**To:** Grace Macdonald  
**From:** Mark Irish  
**Date:** 25 February 2022  
**Subject:** Horsley Logistics Park - Jalco SSDA  
Response to EPA Request for Additional Information

**At:** ESR  
**At:** SLR Consulting Australia Pty Ltd  
**Ref:** 610.19360-M07-v1.0 Jalco EPA  
Response.docx

SLR Consulting Australia Pty Ltd (SLR) was engaged by ESR to prepare an Operational Noise Impact Assessment (NIA) for the proposed Jalco manufacturing facility Development Application (SSD 21190804). The purpose of the report (SLR report 610.19360-R08-v1.3) was to assess potential noise impacts associated with the operation of the Jalco facility located at Lot 201 Warehouse 1, 327-335 Burley Road, Horsley Park, in New South Wales (NSW).

DRAWING TITLE  
LOT 201 WAREHOUSE SECTIONS

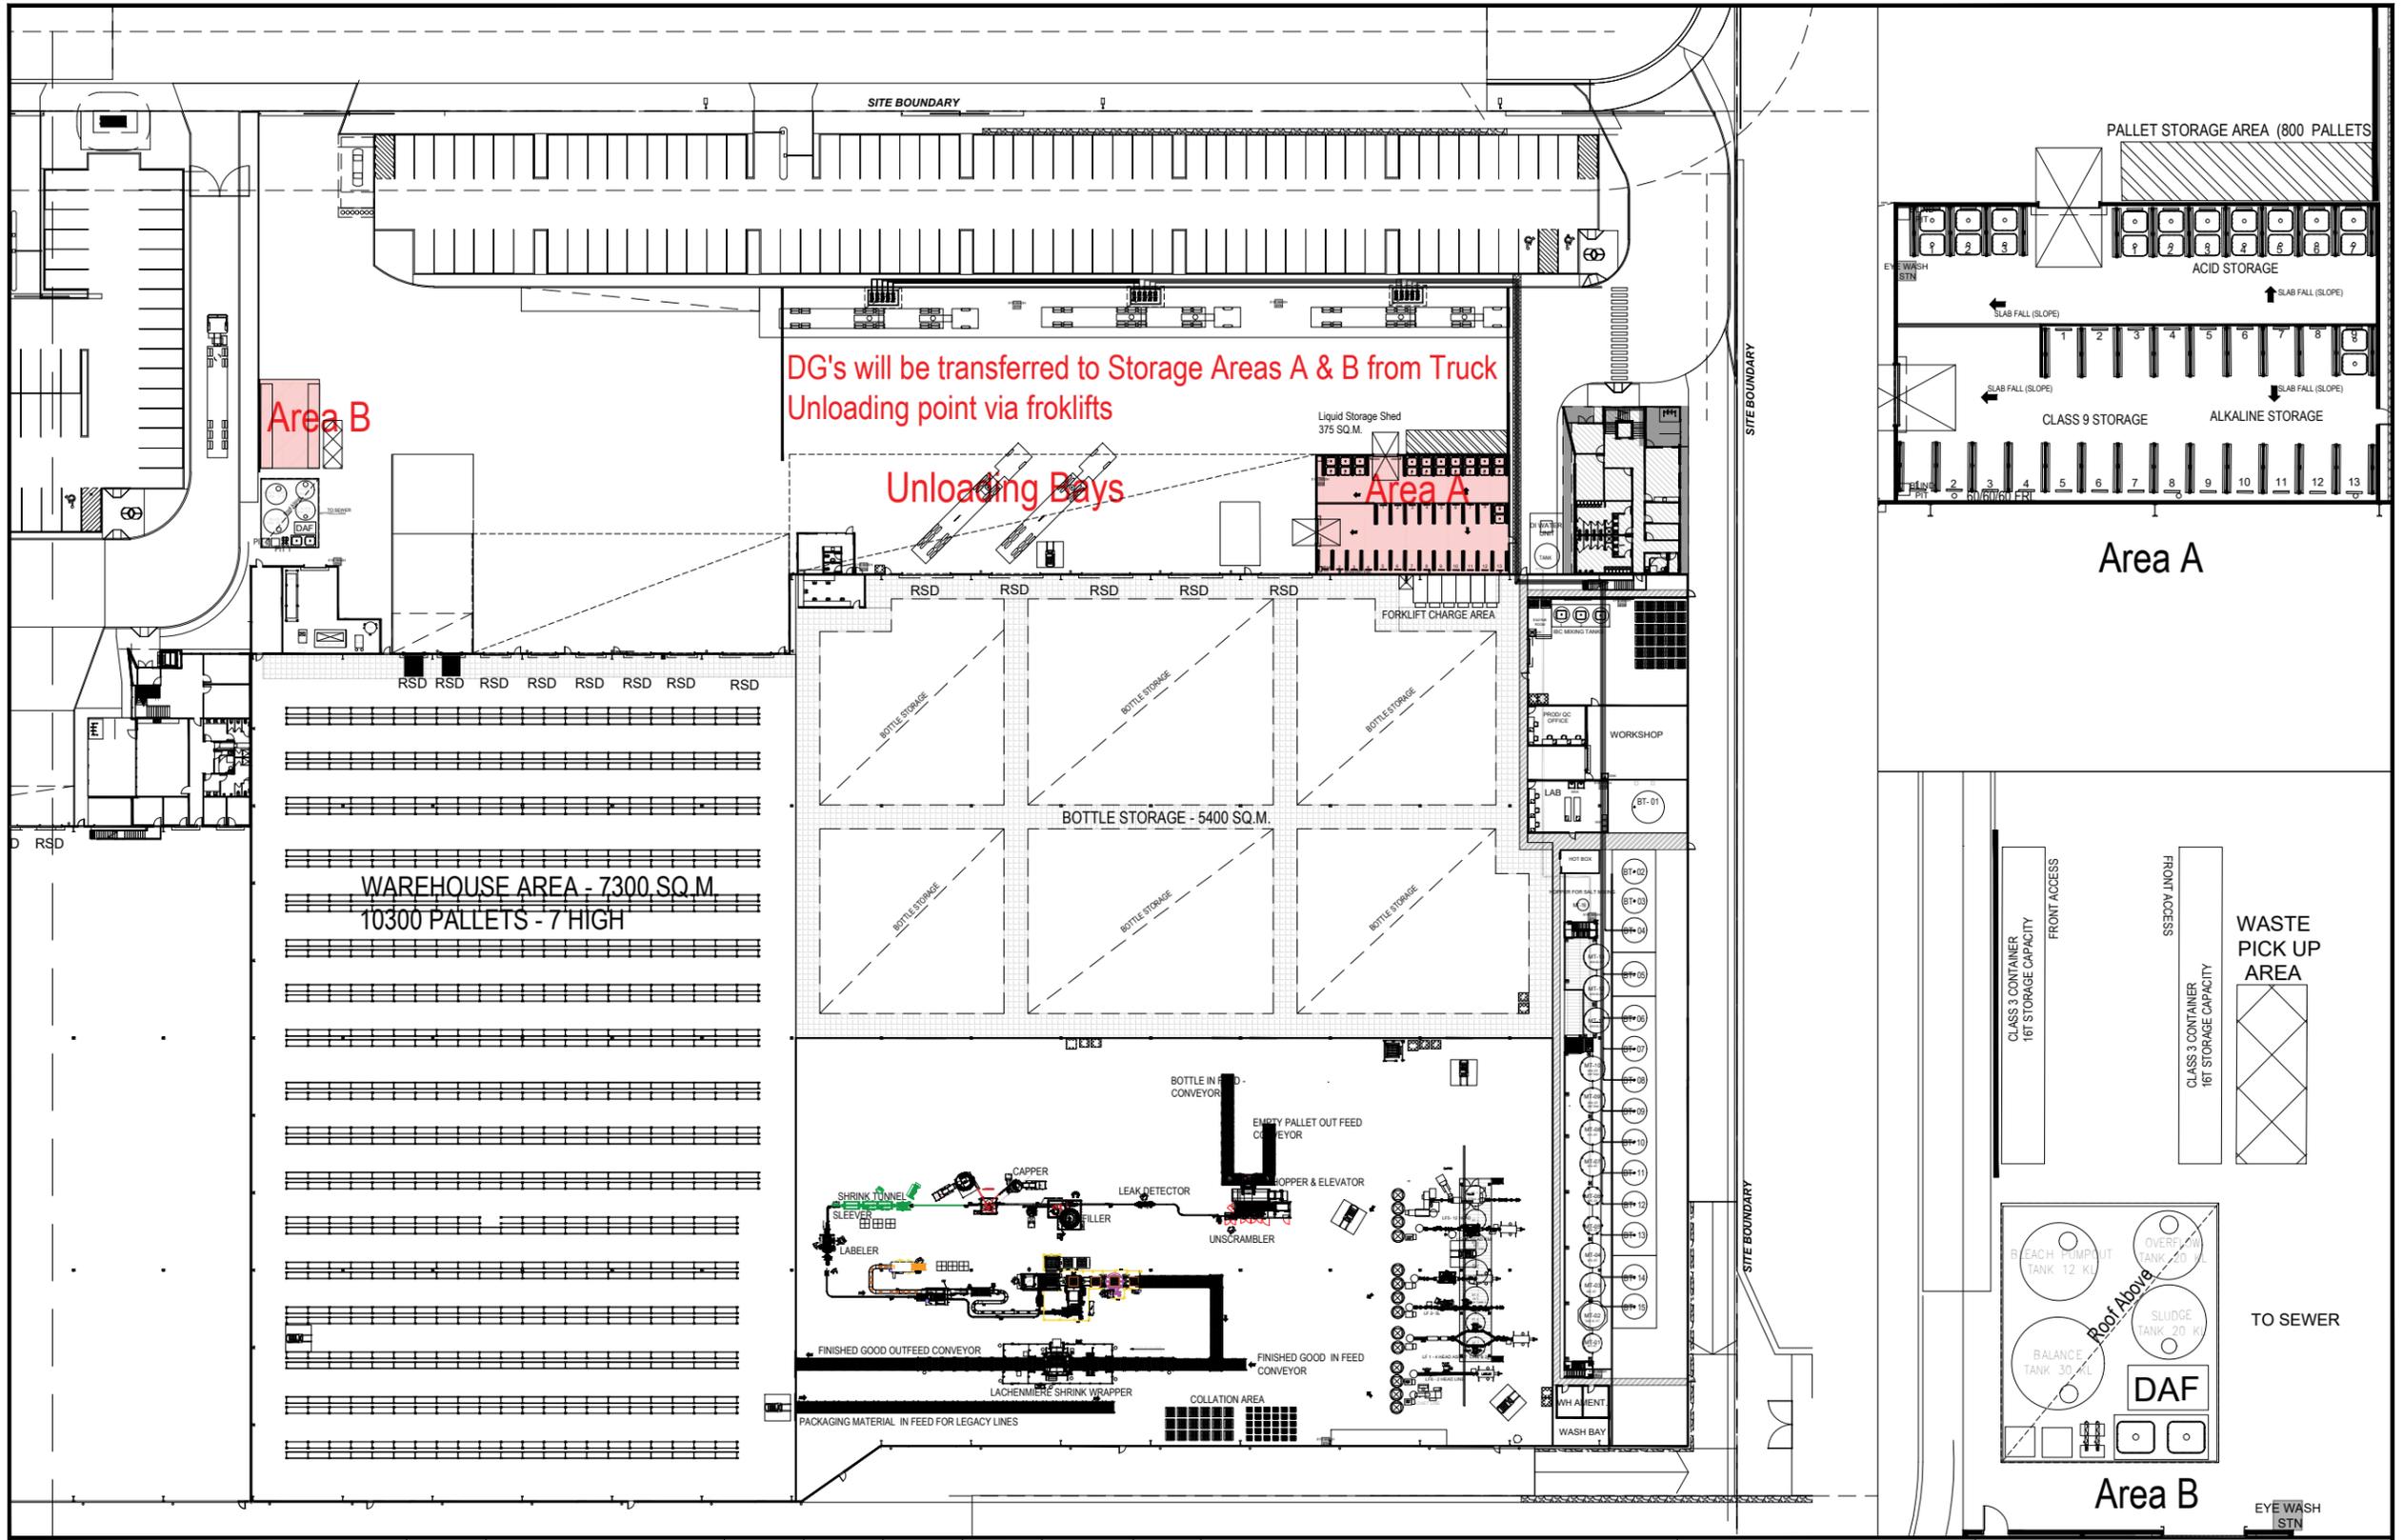
*The Architectural Plans and Air Quality Assessment submitted as part of this SSD application both mention scrubber stacks and the plans appear to show them exhausting at 4 locations in the roof.*

*The NIA does not appear to have considered the scrubber system and exhaust stacks in the assessment.*

The NIA did not include the internal fans and stack discharges required as part of the scrubber system as no information was provided about this equipment at the time of report preparation.

The location of each stack outlet is shown in **Figure 2**. Maximum allowable sound power levels are provided in **Table 4** for each scrubber stack to ensure the stack noise contribution will maintain compliance at the nearest receivers.

The scrubber fans are proposed to be located internally and ducted to the roof so standard engineering controls (e.g. lined ductwork or splitters) are to be included to comply with the maximum sound power limits at each stack outlet.
